**Consultation Response from KC,
Highways Development Management****2026/92089 north of, 5, Field Head Farm Court, Shepley, Huddersfield, HD8 8FH****Erection of single storey detached dwelling and associated access****Date Responded: 3 September 2026****Responding Officer: Sheila Henley****Responding Ref: 12-40/6****Recommendation: No Objection.**

Plan ref: 26/1360/03c - Proposed Block Plan.

scale 1:500 date 07/2025 sheet size A3 dwg. no. 26/1360/03c

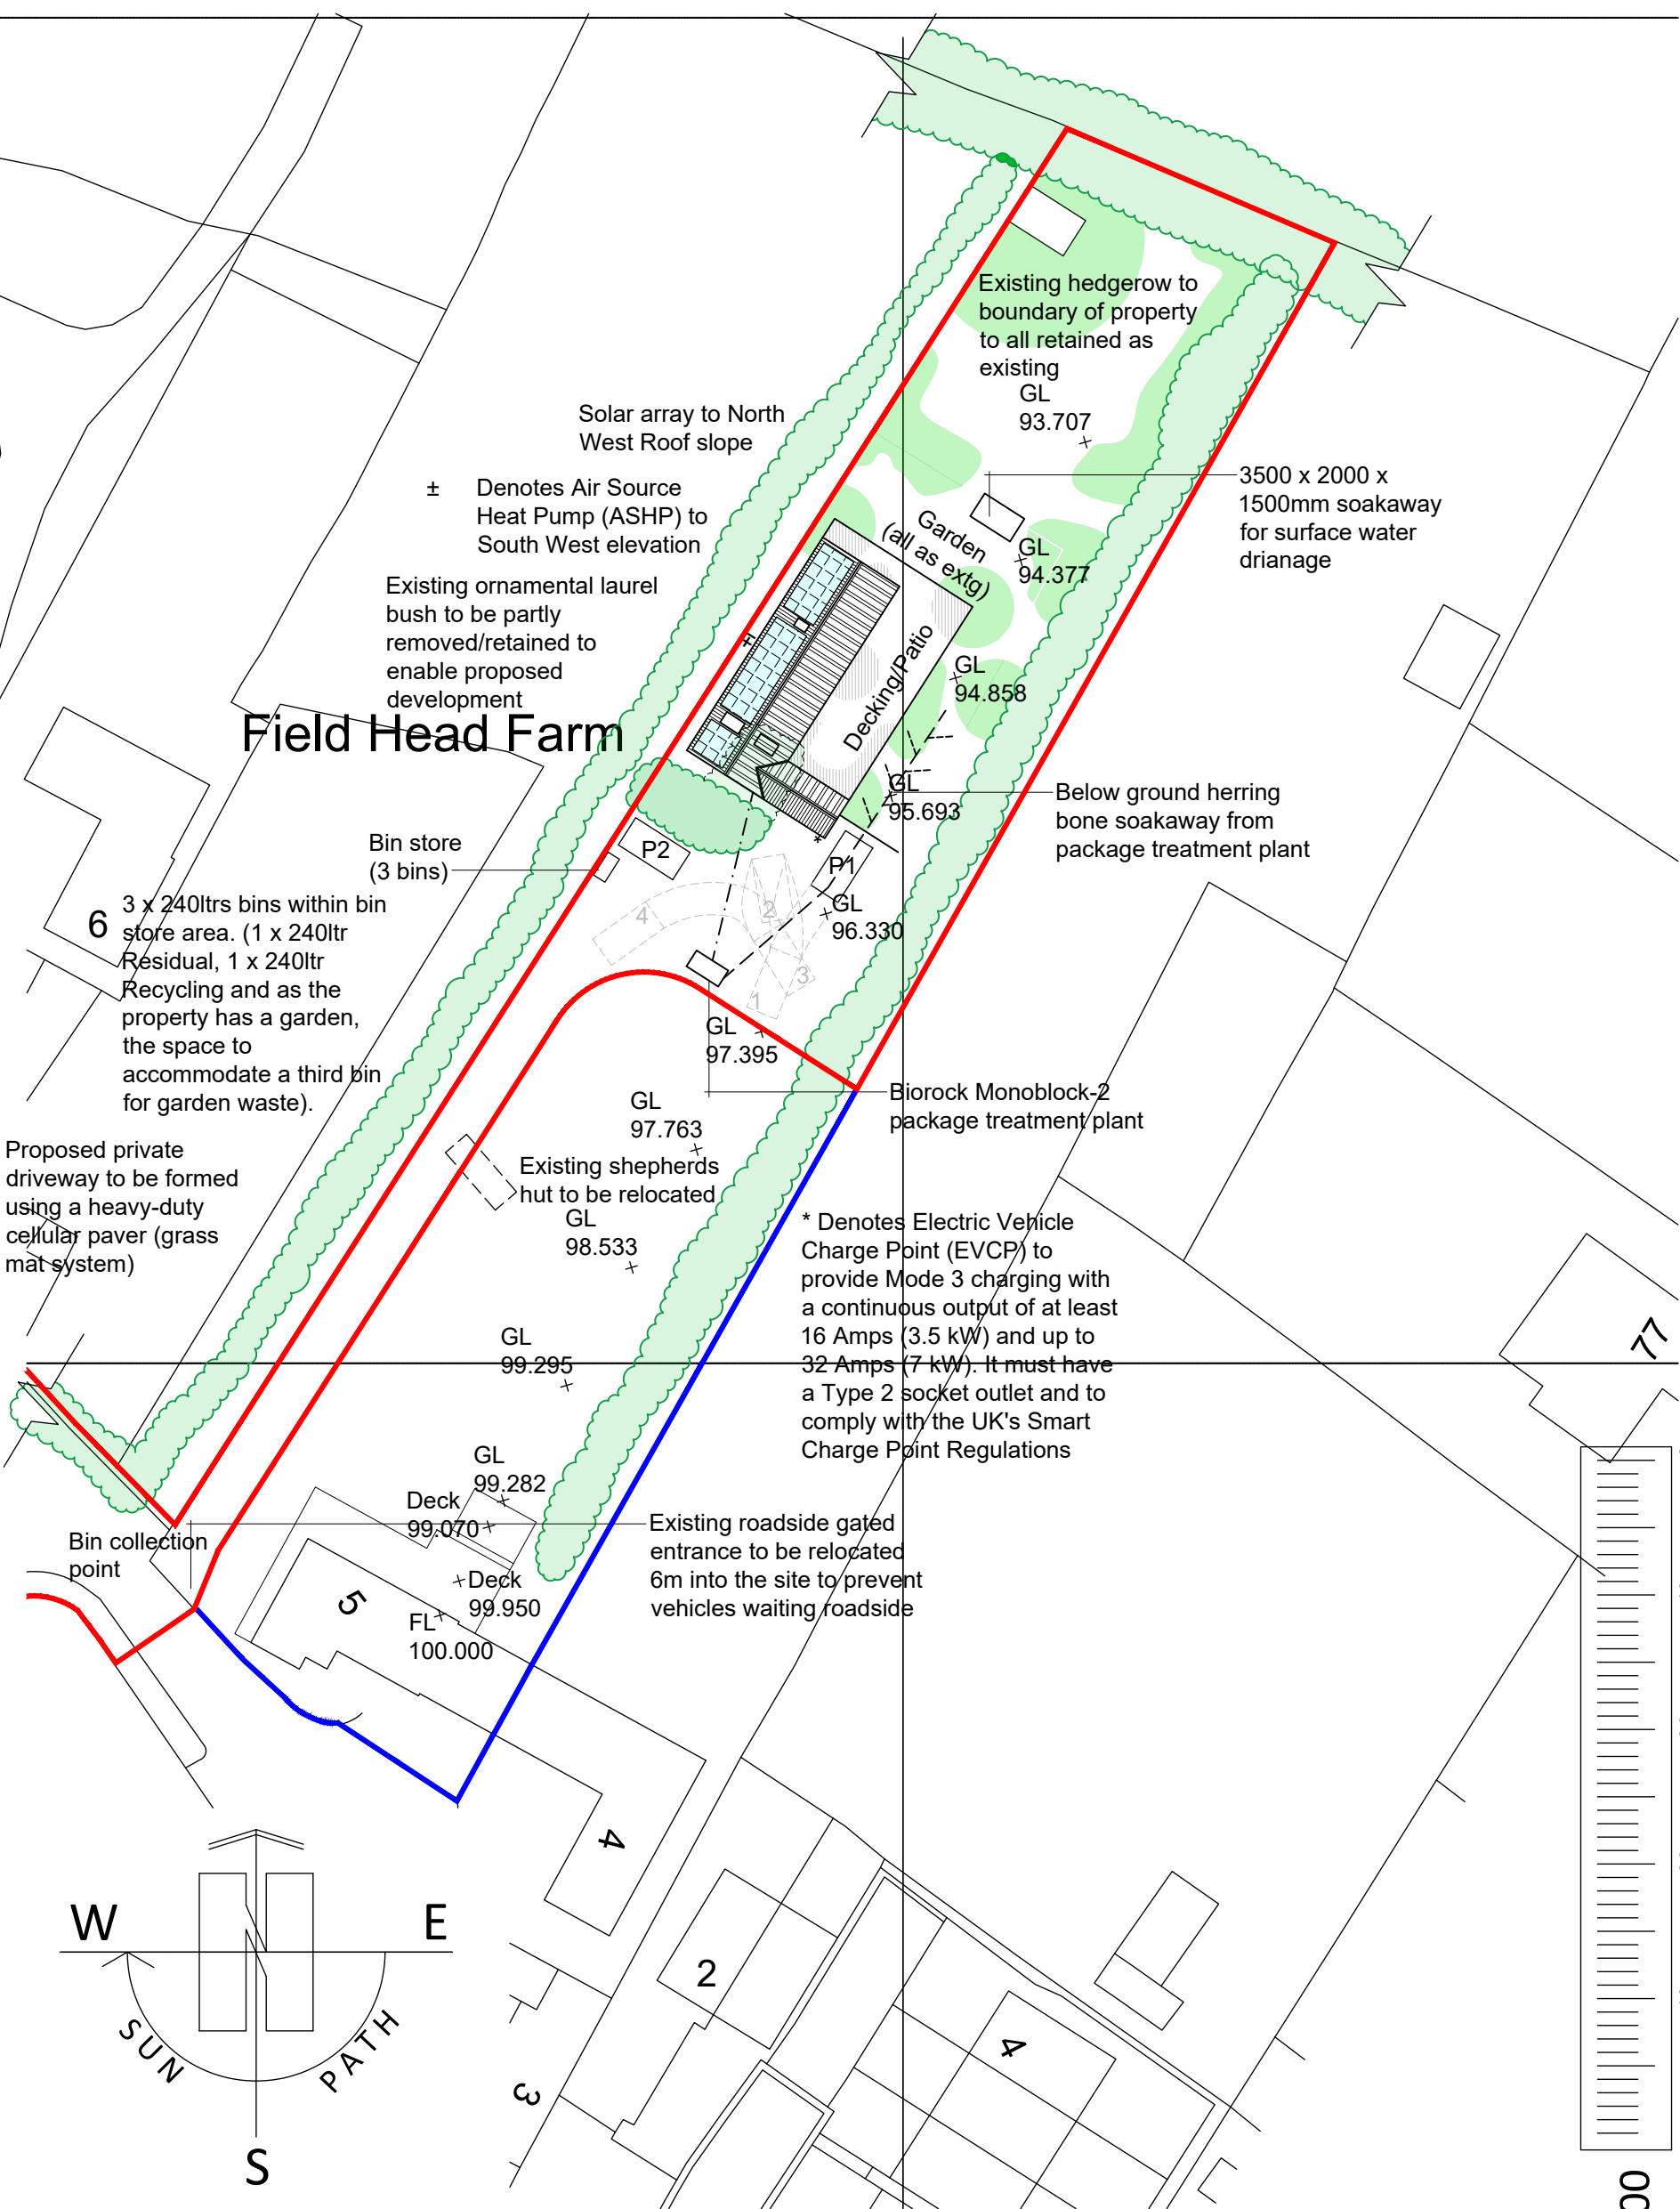
Cycle parking storage is desirable to accommodate one space per dwelling or preferable at one space per bedroom to meet later guidance in LTN 1/20 and policy LP22. It would, also, support policy LP21 and the Kirklees Highway Design Guide SPD to further encourage sustainable travel and mode choice and reinforce Active Travel objectives.

Access is to be taken from the unadopted Field Head Farm Court with the setback by 6.0m of the existing gated entrance that serves as a secondary access for No. 5 to enable vehicles to pull off the street reducing the risk of obstruction. Access for No 5 is to be retained.

Beyond the gate there is to be a porous, heavy duty grass mat driveway of c3.7m width extending some 70m northwards towards a parking and turning area where there is ample space for shared use by pedestrians and vehicles, and for at least two cars to park and manoeuvre. The amount of car parking at two spaces would meet the advice in the KHDG SPD for two-bedroomed dwellings as well as policy LP22 with the intended layout offering flexibility including space for visitors. Parking for No.5 would be retained.

There is space for bin storage, and the pull distance is excessive but is acknowledged as the be preferred arrangement by the Applicants. The bin collection point may require repositioning. The BCP for Field Head Farm Court is understood to be nearer the adopted road at Field Head on the southern side of the street. Waste Services can confirm.

A proposed domestic misting system would negate the need for fire and rescue appliance to get within 45m of the dwelling entrances, although the driveway width is suitable.

Accordingly, the proposal is acceptable in highway terms for no objection to be raised. The Applicant is advised to consider cycle parking storage to improve the sustainable travel offer and clarify the position the bin collection point with Waste Services.
